Phone: 0300 123 6780  
Email: [Kathryn.Walsh@lancashire.gov.uk](mailto:Kathryn.Walsh@lancashire.gov.uk)  
Your ref: 3/2024/0862  
Our ref: 3/2024/0862/HDC/KW  
Date: 20 November 2024

**Location:** Higher Parsonage Farm Parsonage Lane Chipping PR3 2NS  
**Proposal:** Proposal to enclose existing storage facility with timber cladding above two existing stone clad lower walls and double pitched roof over.  
**Grid Ref:** 360613 441833

Lancashire County Council acting as the Local Highway Authority (LHA) does not consider that the application as submitted fully assesses the highway impact of the proposed development and further information is required as set out in this response.

**R. SEED & SON, PARSONAGE FARM – PLAN 5**

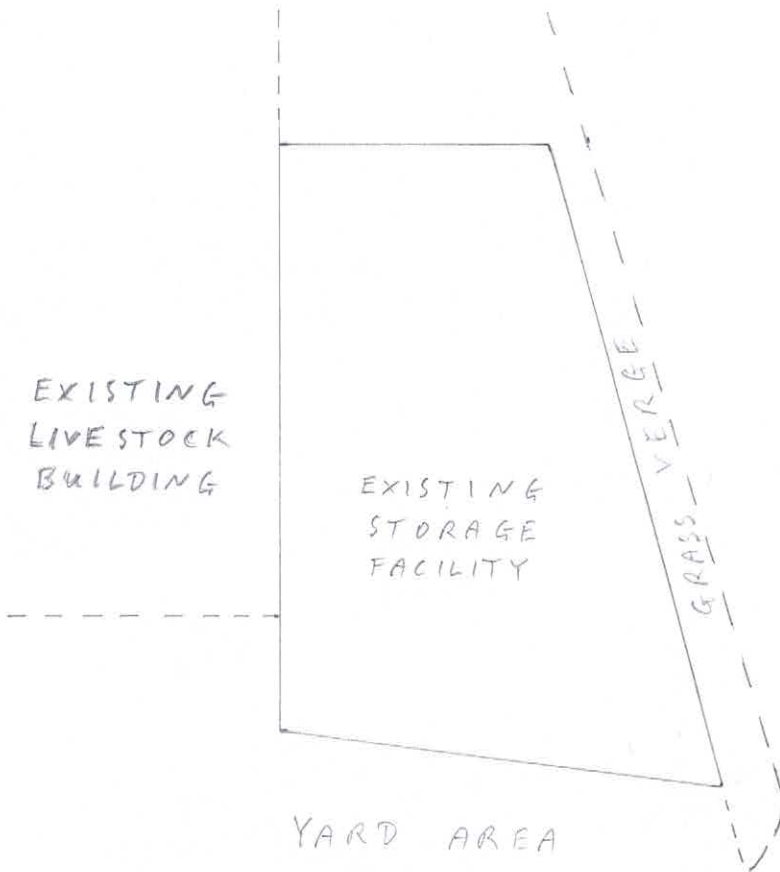
The proposal will create an enclosed storage area which is currently situated close to one of the access points. The LHA has concerns that the proposal will fall within the visibility splay of the access which sits directly next to the proposal which would reduce the view of drivers leading the site. Therefore, the LHA requests that a visibility splay drawing is provided showing the extent of the visibility splay.

To ensure adequate intervisibility between highway users a visibility splay of 2.4m x 214m should be provided to ensure the proposal does not reduce the visibility splay for the access which is situated directly to the East of the proposal. The visibility splay should be wholly within the land which the applicant controls and/or the adopted highway and nothing shall be erected, retained, planted and / or allowed to grow at or above a height of 0.9 metres above the nearside carriageway level which would obstruct the visibility splay of the proposed access.

The applicant should provide accurate details of the required sight line requirement, before determining the application.
